**KIRKLEES METROPOLITAN COUNCIL
INVESTMENT & REGENERATION SERVICE**

| Reference No: | 2025/62/91384/E |
| Site Address: | 17, Market Street, Heckmondwike, WF16 0JY |
| Description: | Change of use of existing basement from storage (Class B8) to a single-person House in Multiple Occupation (Class Sui Generis), including internal alterations |

DRAWING TITLE  
 Proposed Drawings

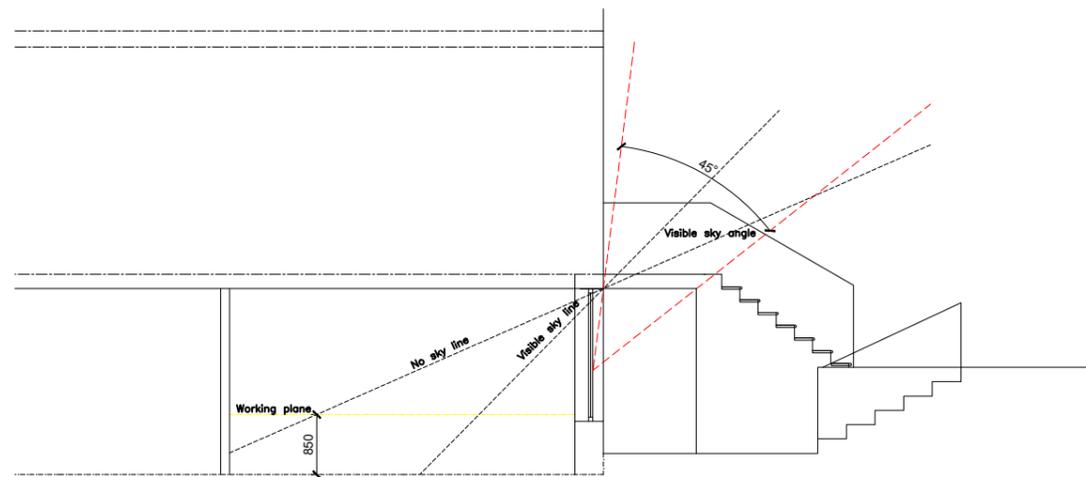
The proposed development would not involve any works to the exterior of the front of the property. To the rear, the yard would be stepped down to allow more light into the basement window. This is not considered to cause any significant harm in terms of residential amenity. Therefore, no additional harm to visual amenity would be caused over and above the existing arrangements on site.

The applicant has submitted a drawing showing the ‘visible sky line’ to the proposed bedroom. Whilst this is acknowledged, the drawing only shows part of the room as within the ‘visible sky line’ with a significant proportion of the

room not included. Whilst some light would be provided, the bedroom would still have a view out onto a stairwell thus the proposed bedroom would not have an acceptable outlook. It must also be noted that the space which the only window faces, is communal amenity space for the entire property which would be operated as a HMO. It is therefore considered that a bedroom in this location has the potential to be overlooked by other occupants of the building.

It is therefore considered that the proposed bedroom would not provide sufficient outlook or natural light to the future occupants and there are concerns that the scheme would result in overlooking harm as well.

It is therefore considered that cumulatively the impact of lack of outlook and natural light, as well as the potential for overlooking harm would not result in an acceptable level of amenity for the future occupiers. Thus, failing to comply with LP24 and LP15 d) of the Kirklees Local Plan, the aims of chapter 12 of the NPPF and Principle 6 of the Housebuilders Design Guide SPD.
